OXFORDSHIRE COUNTY COUNCIL'S RESPONSE TO CONSULTATION ON THE FOLLOWING DEVELOPMENT PROPOSAL

Application no: 23/03366/OUT

Proposal: Outline planning application for up to 117 dwellings and associated open space with all matters reserved other than access

Location: Land Opposite Hanwell Fields Recreation Adj To, Dukes Meadow Drive, Banbury

Appendix F
Proposed Site Access
MAC drawing no. 802-TA10A

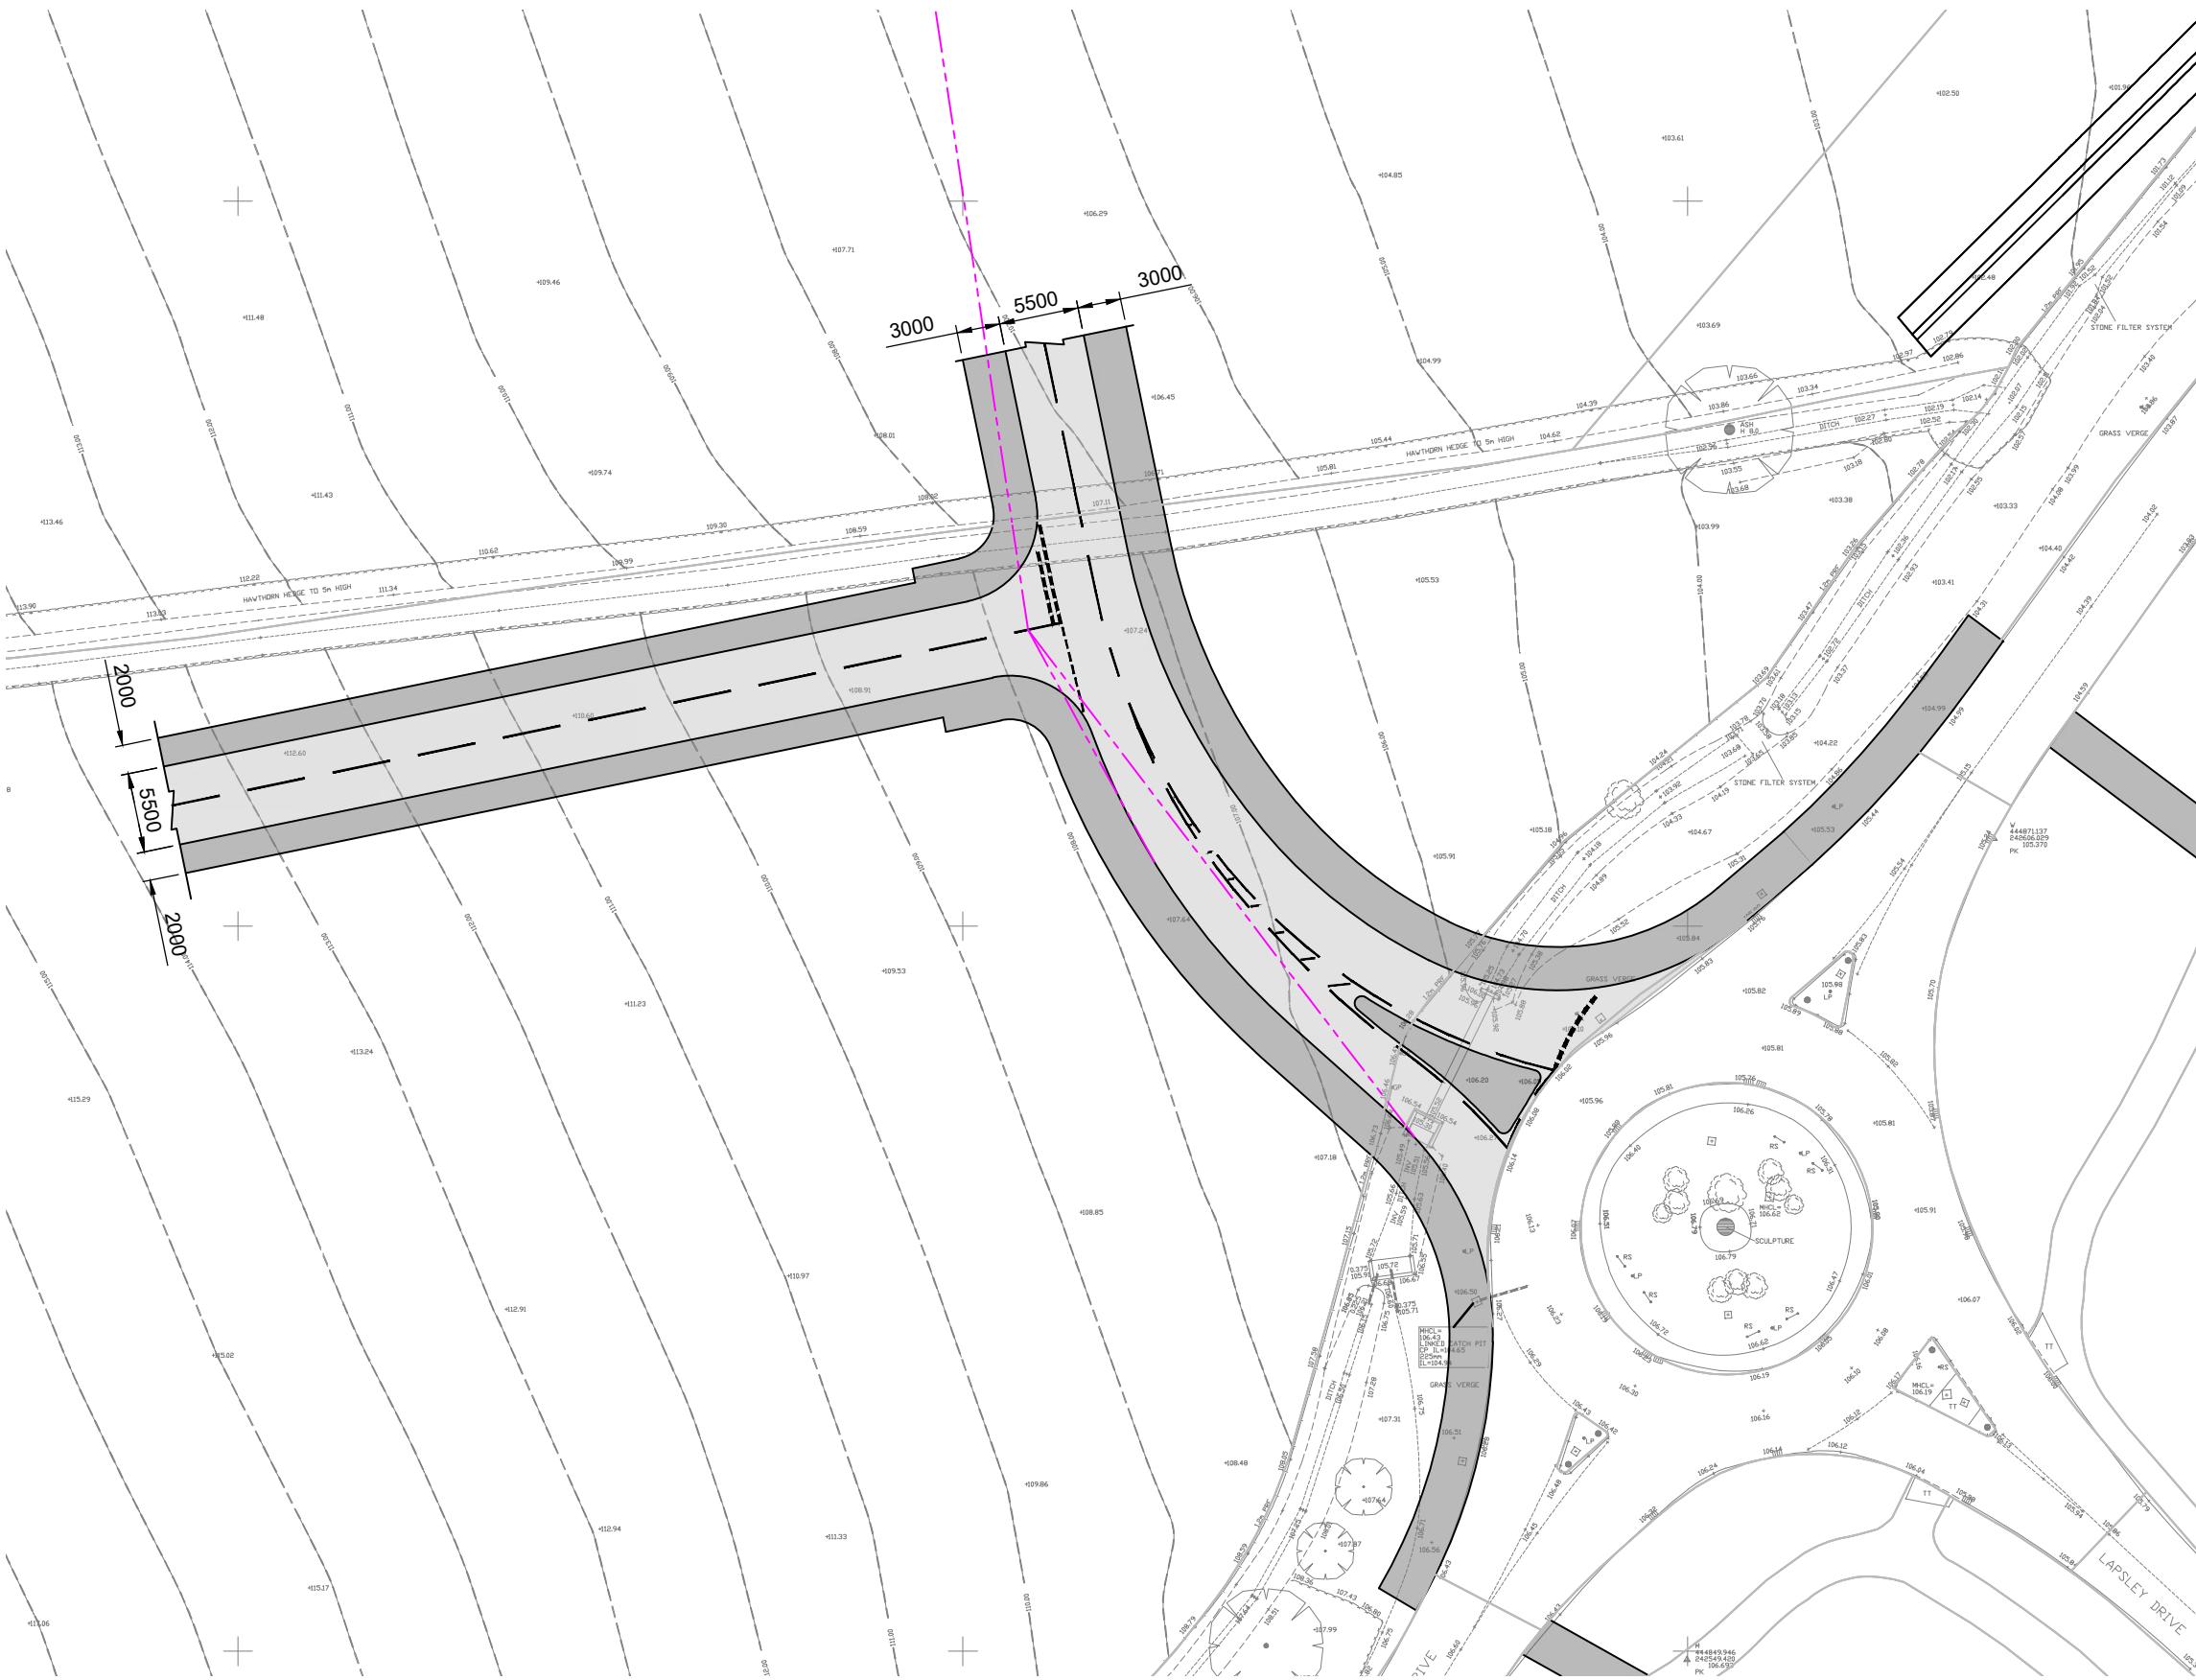
The new roundabout arm will have a carriageway width of 5.5m. Either side of the access road leading into the site a 3m wide shared footway / cycle will be provided. The application proposes to connect onto the existing footway / cycleway provision on the southern / eastern side of Dukes Meadow Drive via two new uncontrolled crossings either side of the roundabout.

OCC however, find that this is not sufficient and would like to see one of these uncontrolled crossings to be upgraded into a signalised crossing which would enable pedestrians and cyclists to safely cross Dukes Meadow Drive. The preferable point would be to the south of the roundabout to benefit from sufficient verge on either side of the carriageway. (To be conditioned)

8.2 – regarding point 8e and 8f - Raised Pedestrian/Cyclist priority crossing at all junctions. In this case the 2 access to the site. One at the roundabout and the other access as well. Also ensure that there are safe crossings from the development arm of the roundabout to the Lapsley drive, to ensure residents can cross into the Hanwell Fields Shops, schools and community centre safely.
